RiverOak Strategic Partners

Response to ExA's Rule 8(3) Letter dated 03.04.19

Project Name:	Manston Airport Development Consent Order
Application Ref:	TR020002
Submission Deadline:	5
Date:	05 April 2019

Manston Airport – Addendum TA and Transport ES Chapter – ExA Omissions Response

Figure 14.9
Locations requiring further
assessment

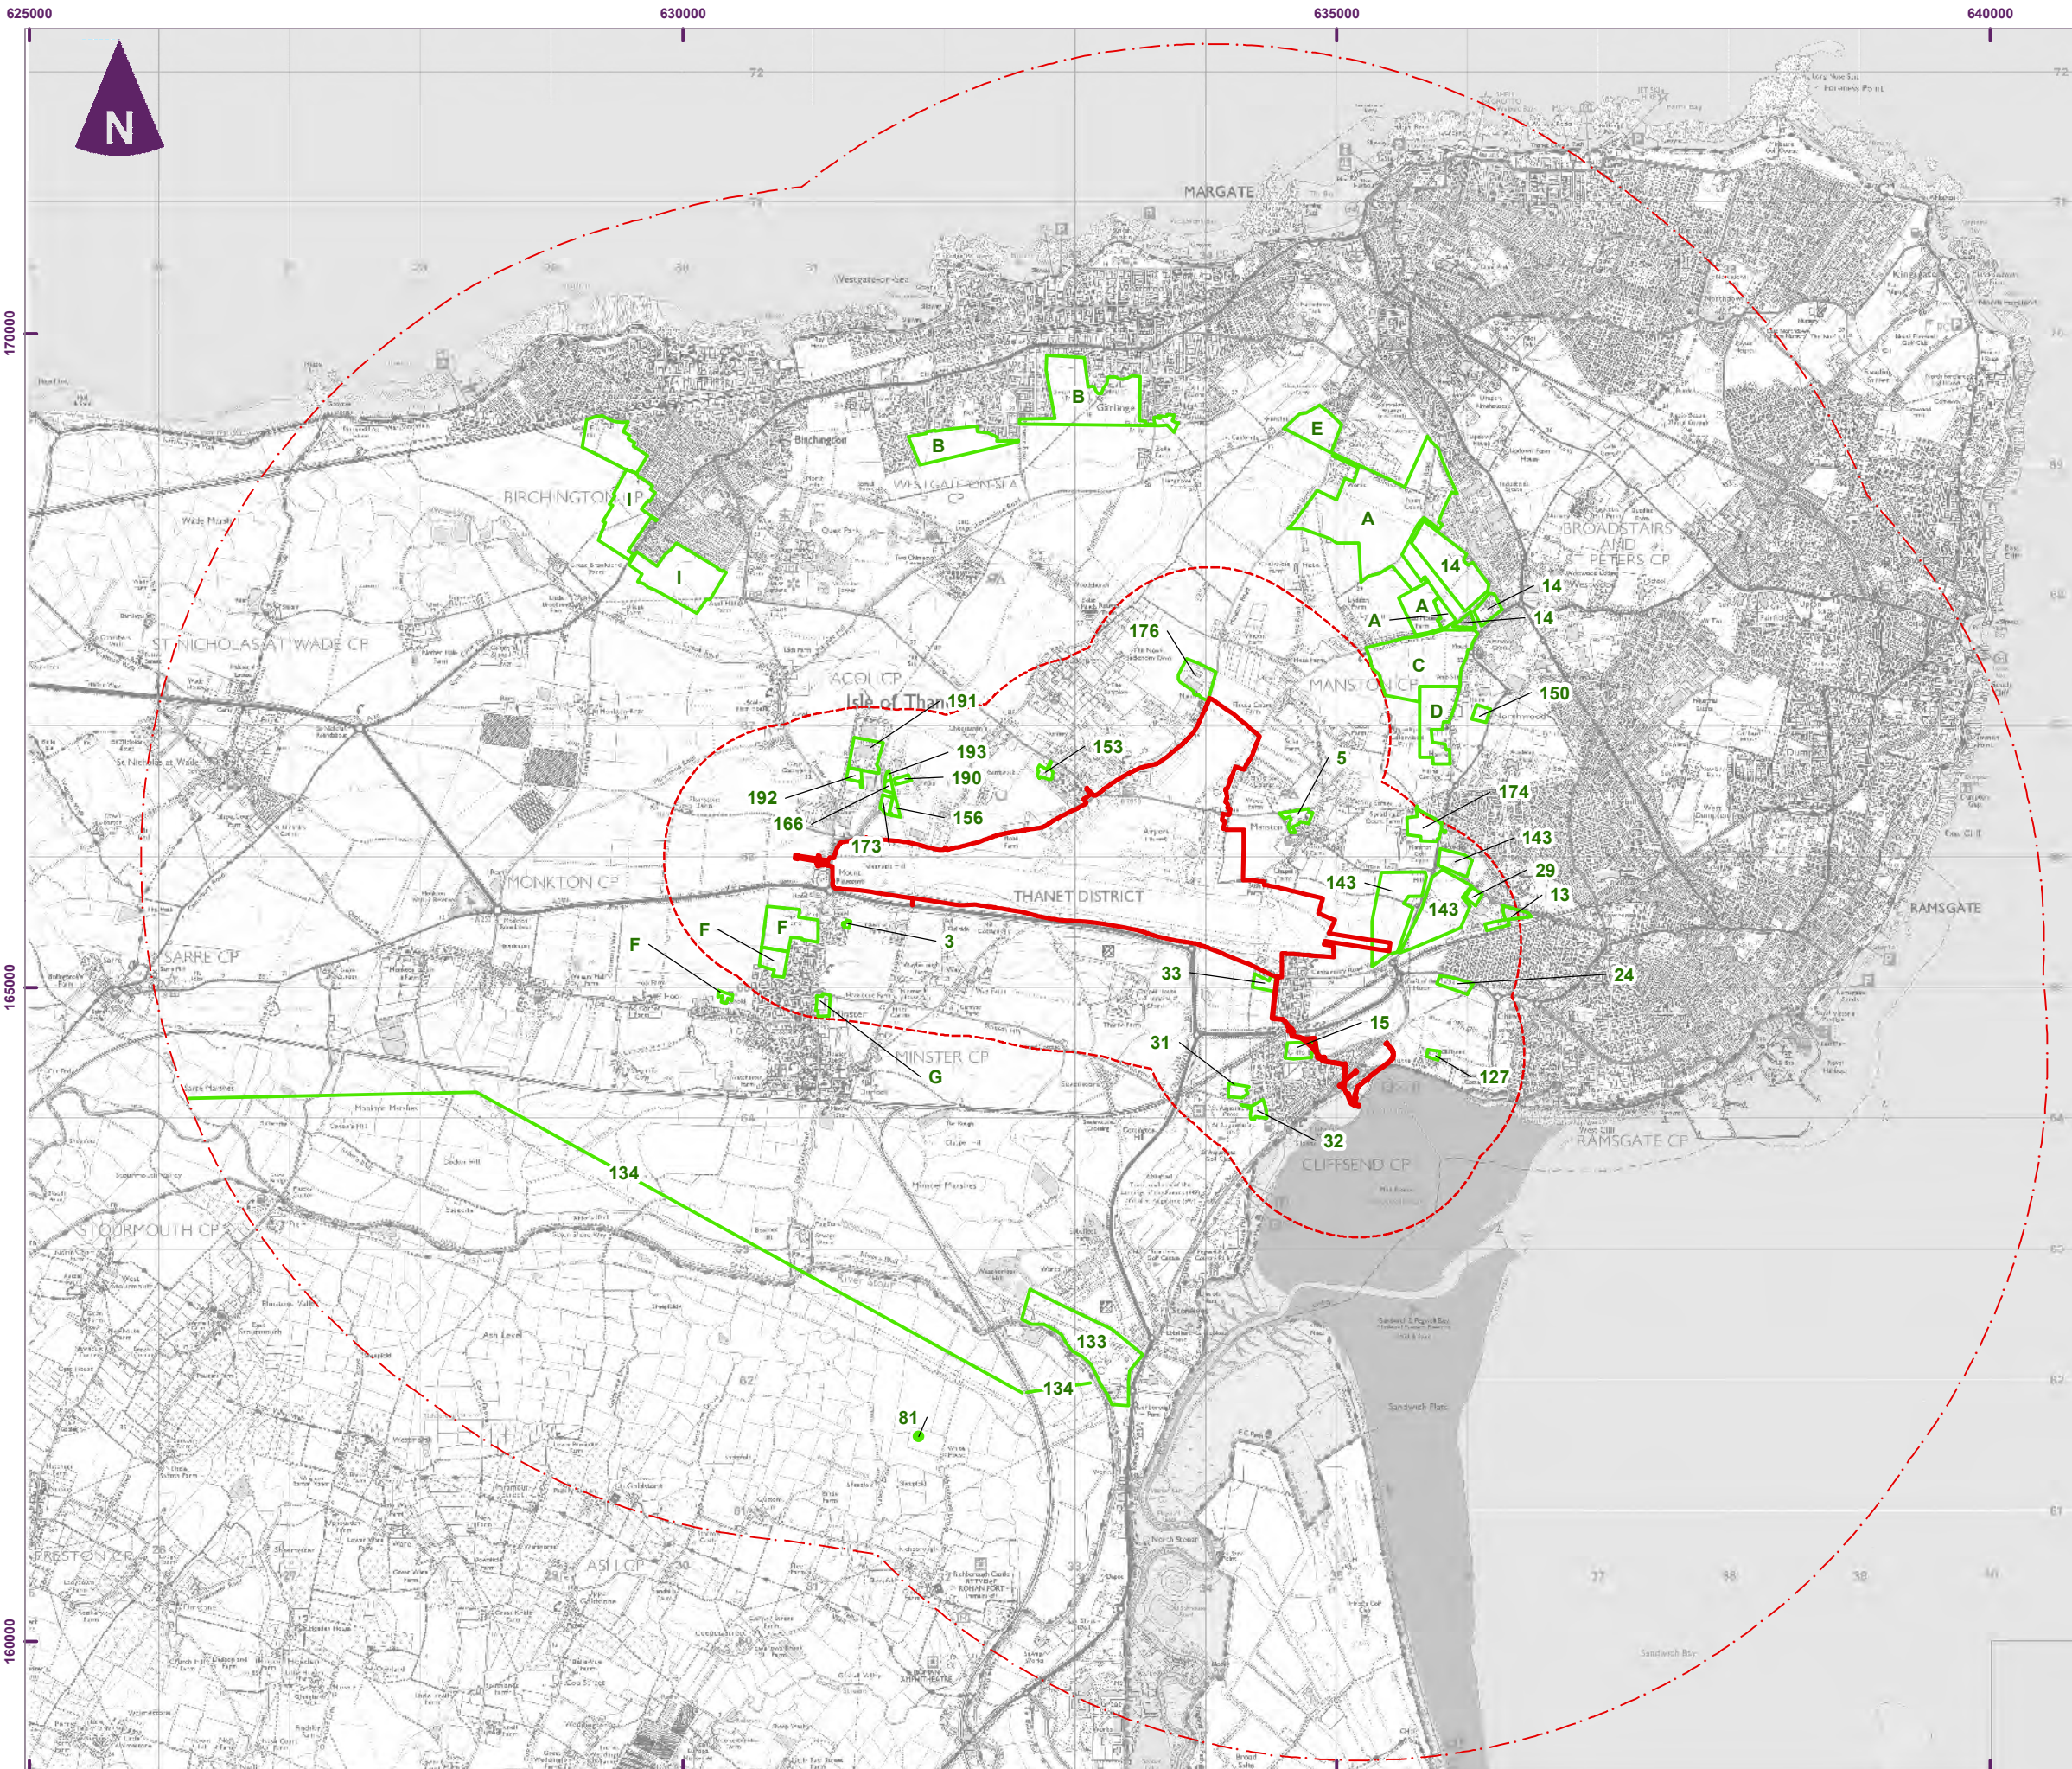
Reference	ExA Omissions	Wood Response
iv	Table 14.20 identifies link 34 as needing further consideration (so does Figure 14.9), but it is not considered further in section 14.10.	This has been added to section 14.10
v	The 'AM peak all vehicle' % increase for link 39 Manston Road north of NGA link is highlighted in red (22%) in Appendix 14.3, but this is not reflected in Table 14.20 of the main document and has not been considered further.	The 22% increase in Appendix 14.3 should not have been highlighted and has been corrected.
vi	There are some missing data points in the table in Appendix 14.3. Should these all be 0?	These should be 0 and have been added.
vii	The 'Rule' for Shottendane Road north east of the junction with Park Lane (Link 11) in Appendix 14.3 does not match that set out in Table 14.17 of the main document.	This is a typo in the Appendix 14.3 table which has been corrected to read Rule 1.
